Re: 2nd Site Development Plan Review, King Soopers #147 – Falcon Market Place

Please find below our re-submittal package addressing the comments received on March 11, 2020. To facilitate your review, we have included the original comments in italicized font, and have provided our responses in **bold**.

SITE PLAN

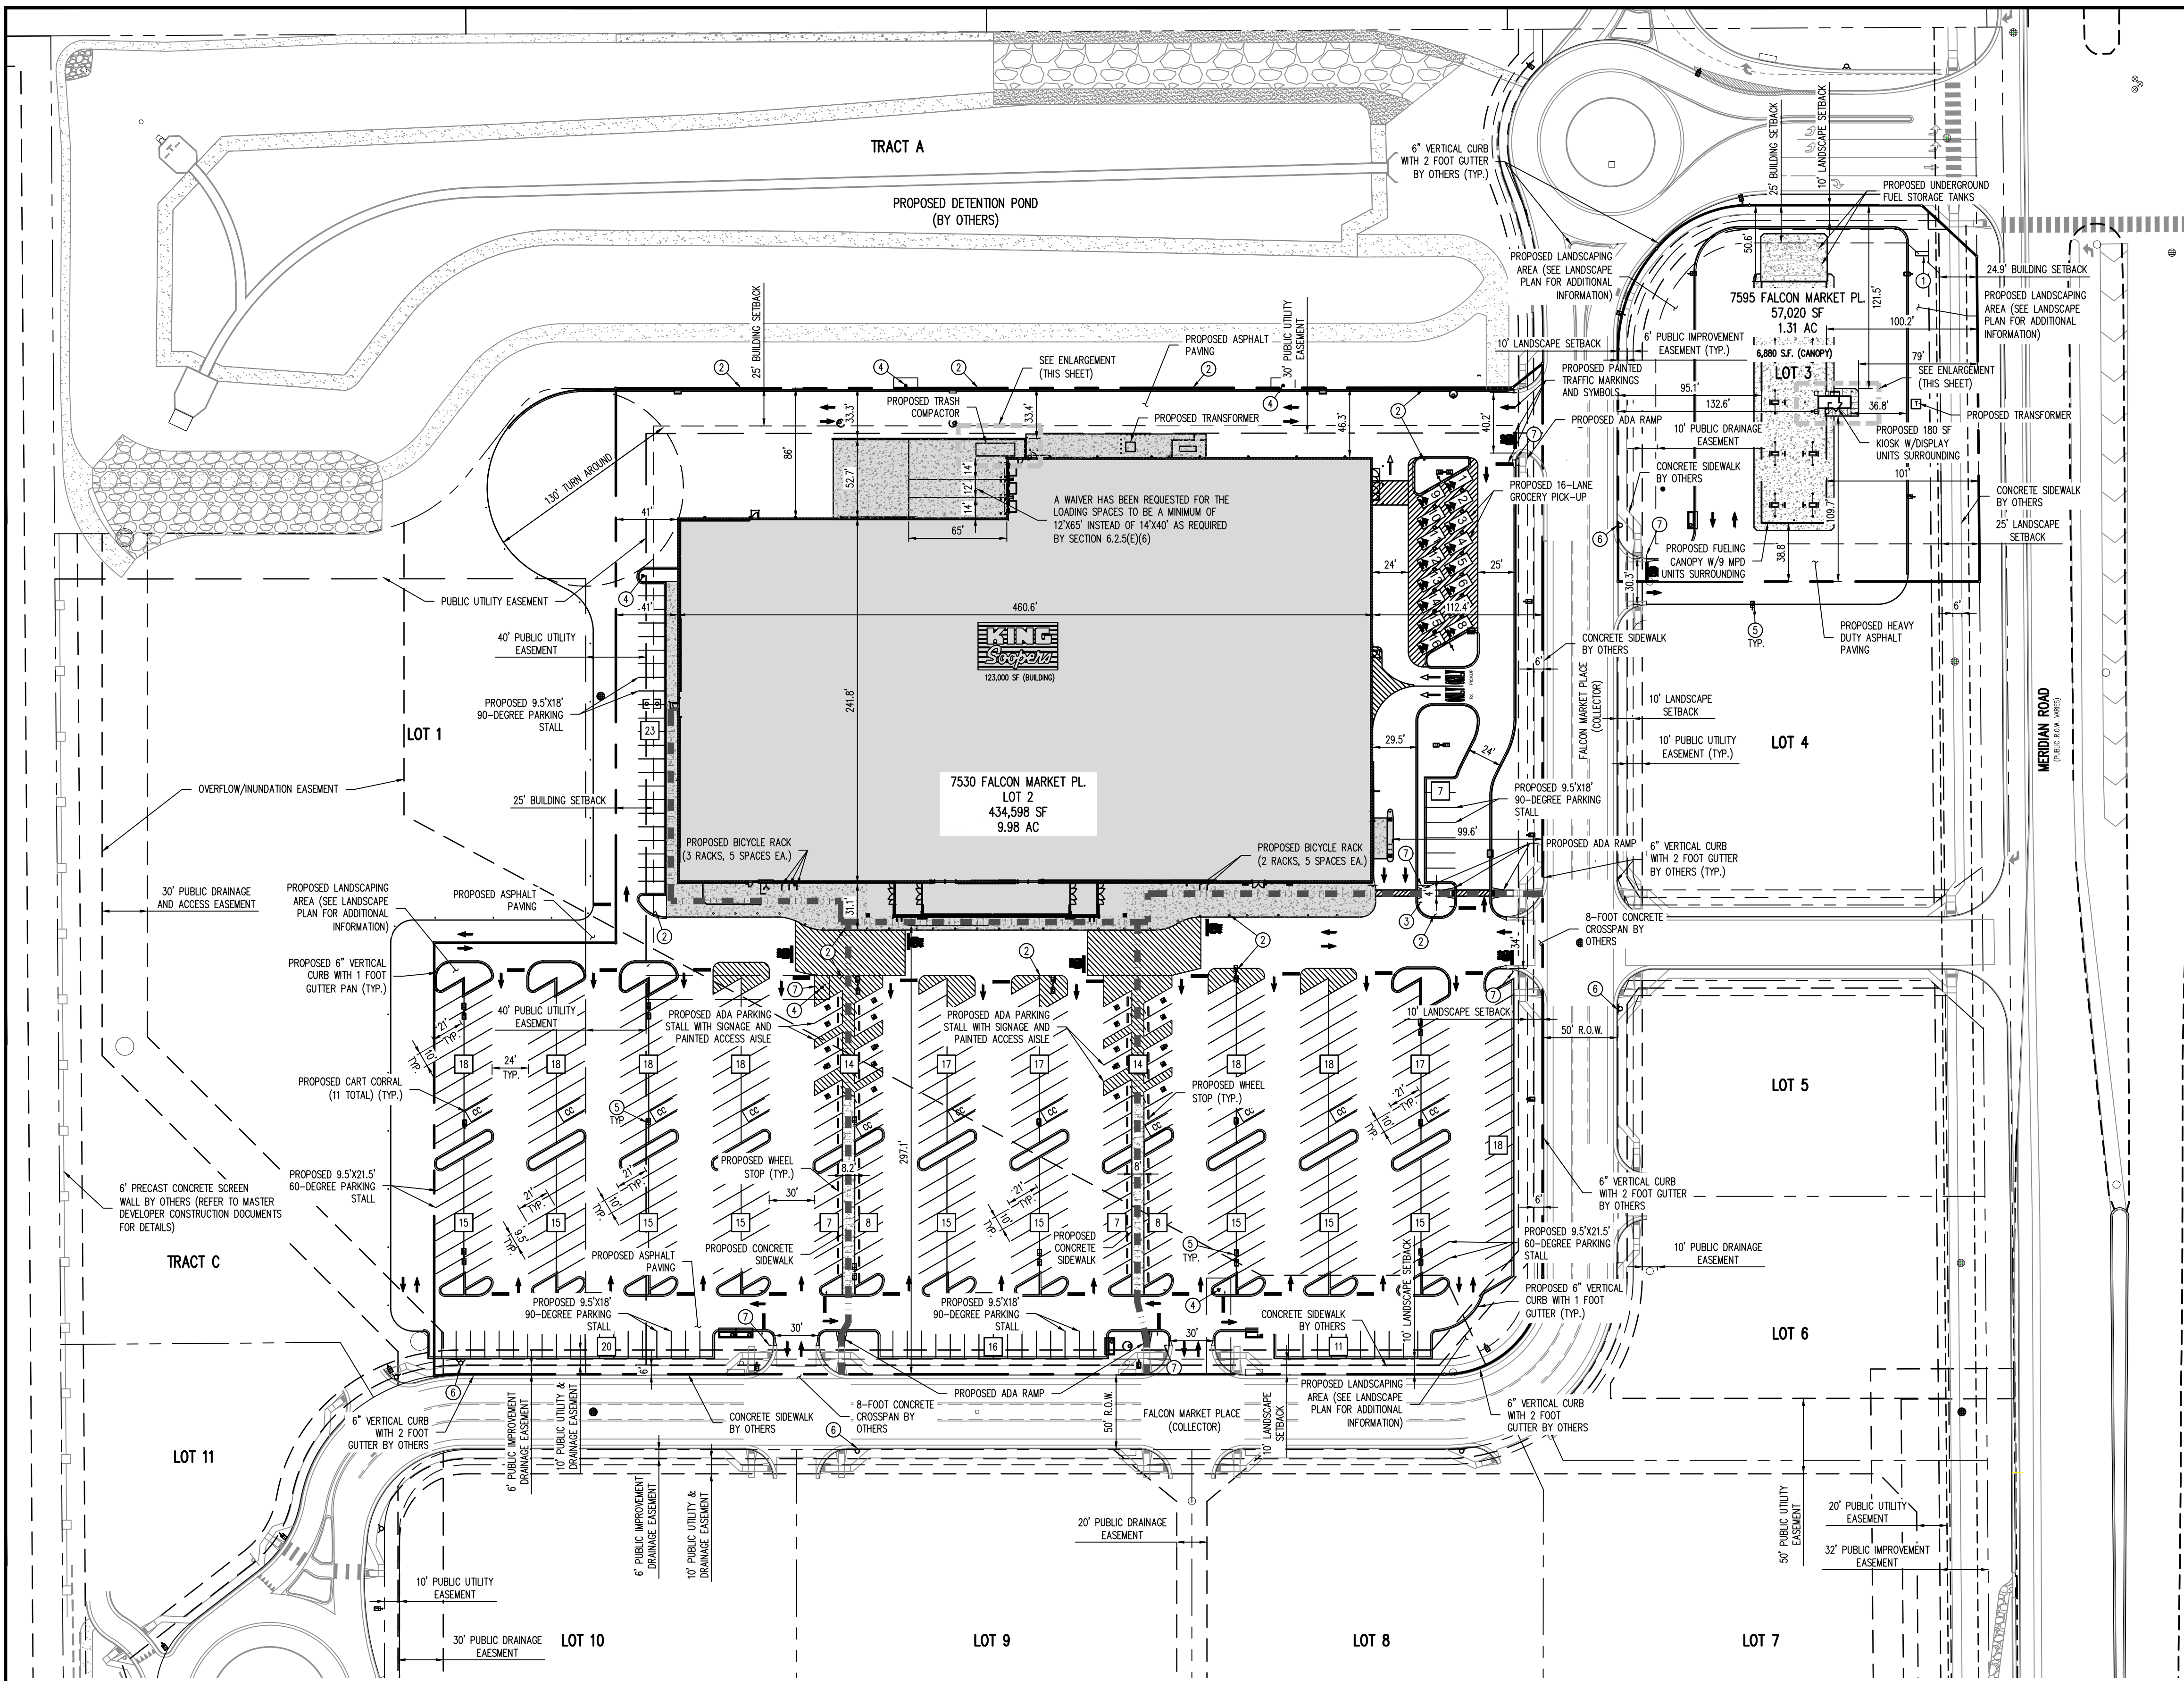
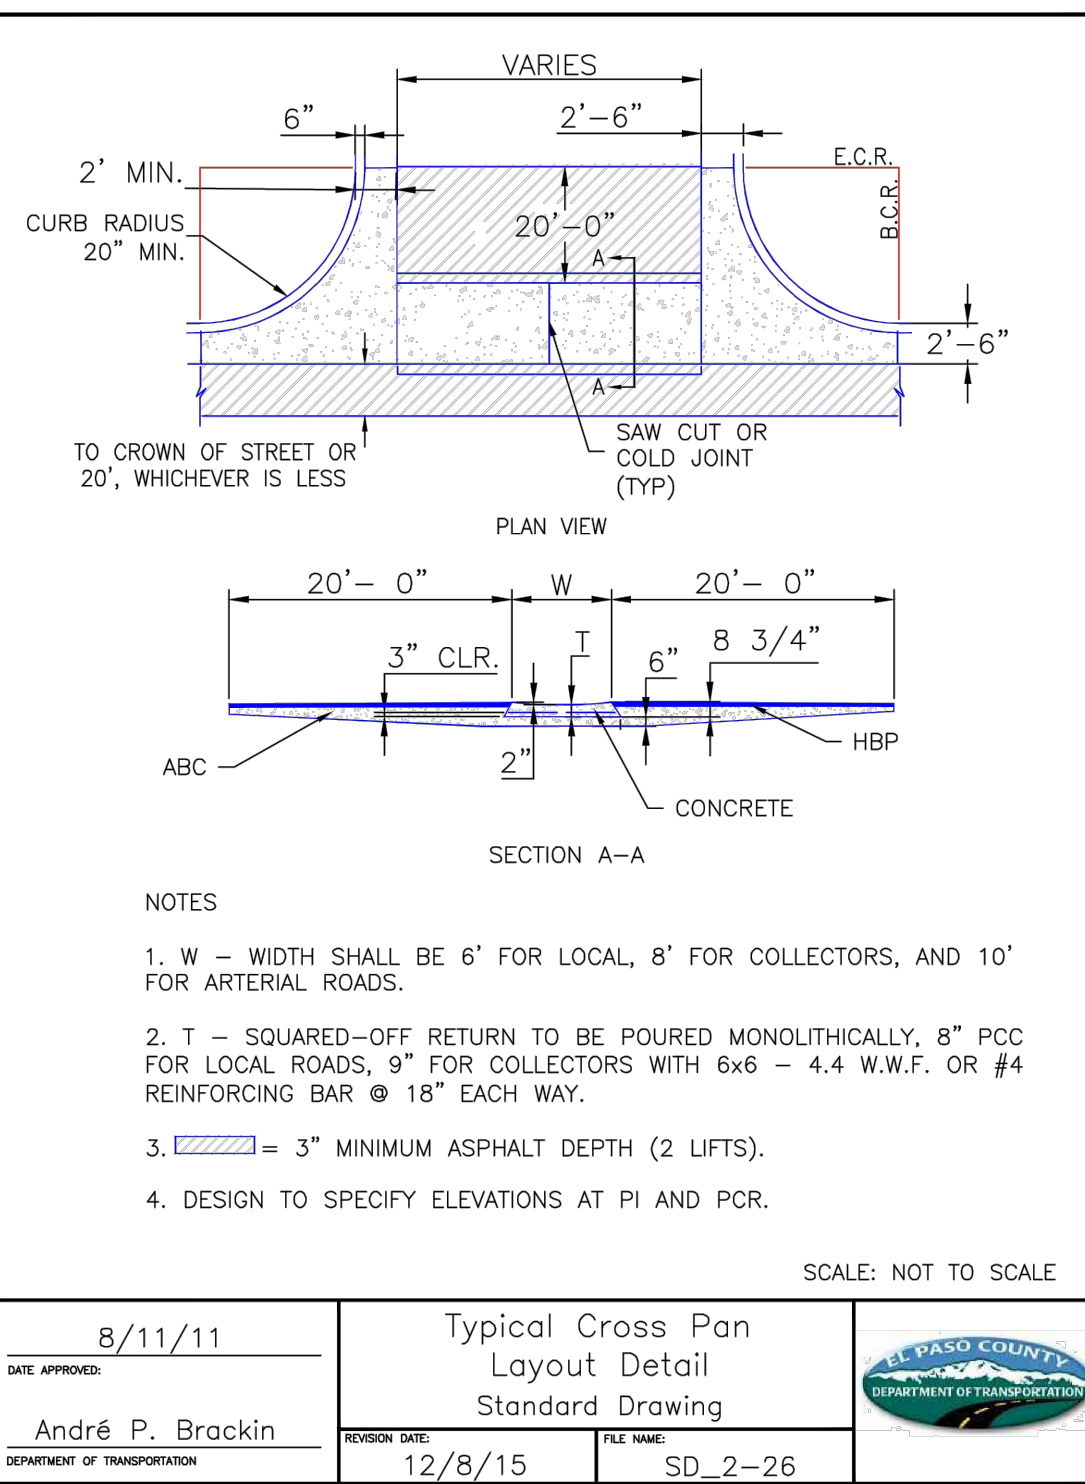
1. **Resolved**
2. **Resolved**
3. **Unresolved**, Provide a note stating that approved Base Flood Elevations (BFEs) are being established through the LOMR process and identify the LOMR.
Galloway Response: Note has been added in the “General Notes” section.
4. **Unresolved** See site plan redlines for additional comments.
Galloway Response: Redline responses are provided on the plan pdfs.
